From: [Jordan Bovee](#)
To: [Zach Torrance-Smith](#)
Cc: [Guy Moura](#); SEPA@dahp.wa.gov; [Shalena Bent](#); [JOHN Sirois](#); [Darnell Sam](#); [Milton Davis](#); [Kiana Sam](#); [Karen Capuder](#)
Subject: Re: SX-25-00010 Gott - Notice of Application
Date: Tuesday, October 7, 2025 5:58:54 PM
Attachments: [CCT Trad. Terr. 2025.pdf](#)

We have completed our review of the proposed shoreline exemption permit SX-25-00010 Gott for parcel #300534.

To: All Staff
From: Environmental Health
Date: September 9, 2025
Subject: SX-25-00010 GOTT

TO: All Staff
FROM: Public Works Plan Review Team
DATE: September 30, 2025
SUBJECT: SX-25-00010 Gott

9/22/2025

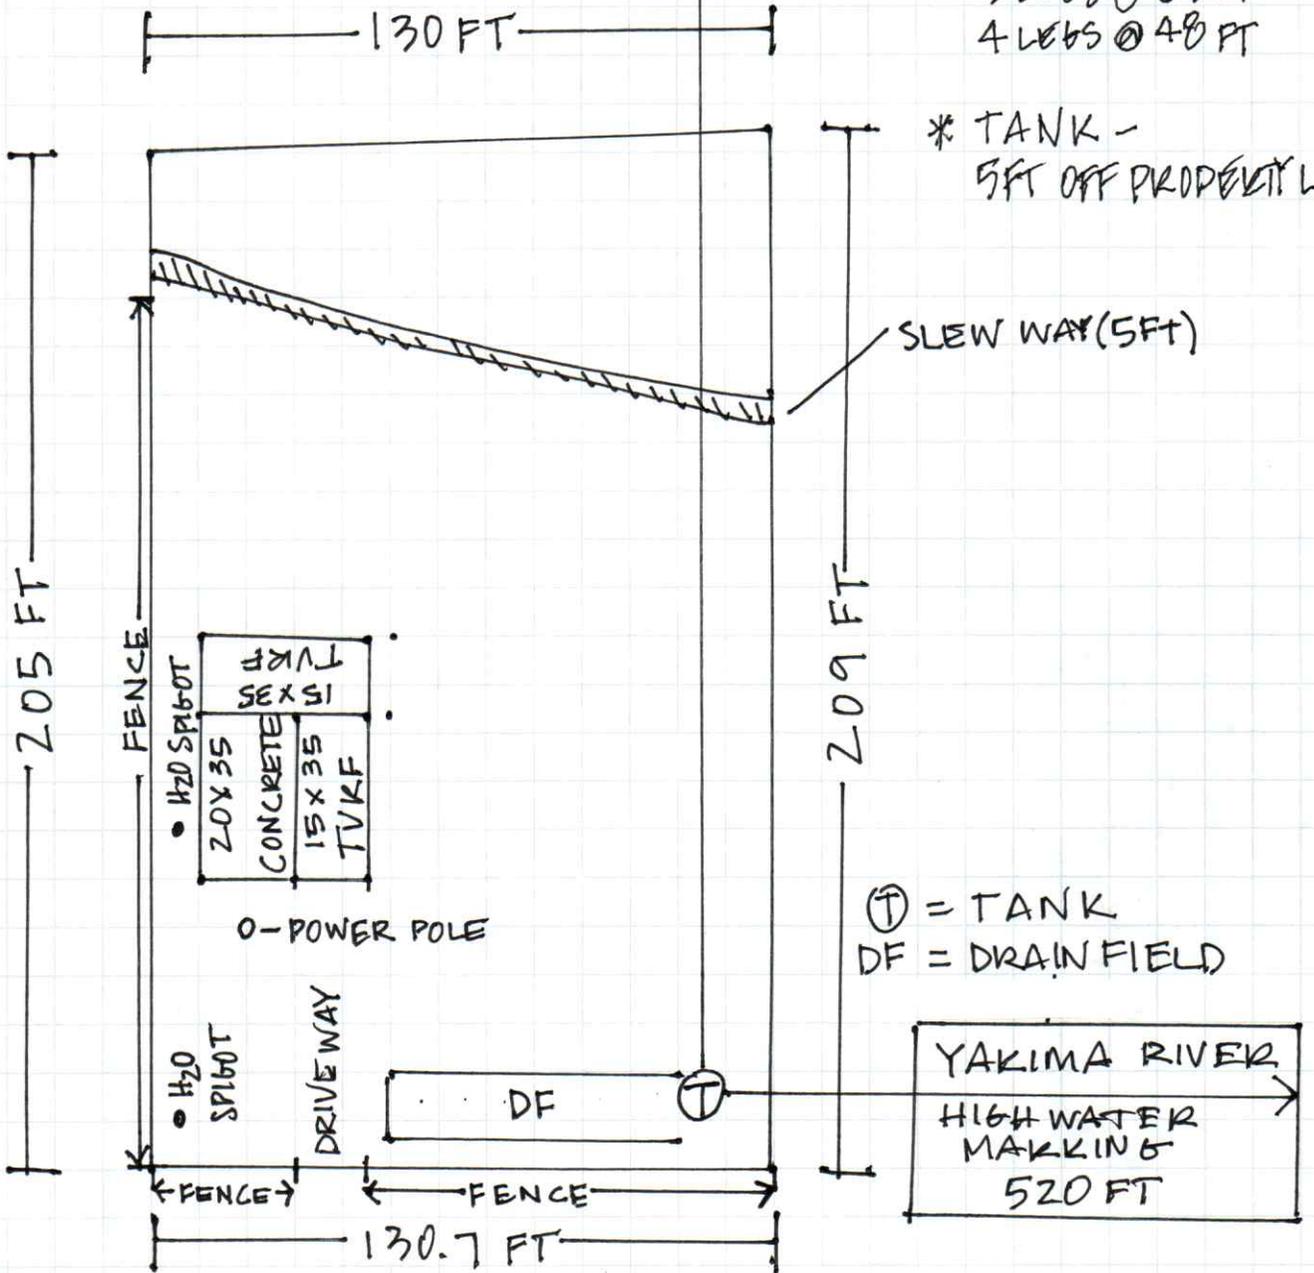
Drinking Water	• N/A
Wastewater	• Maintain 100ft setbacks from any surface water. If unable to a waiver may need to be completed.
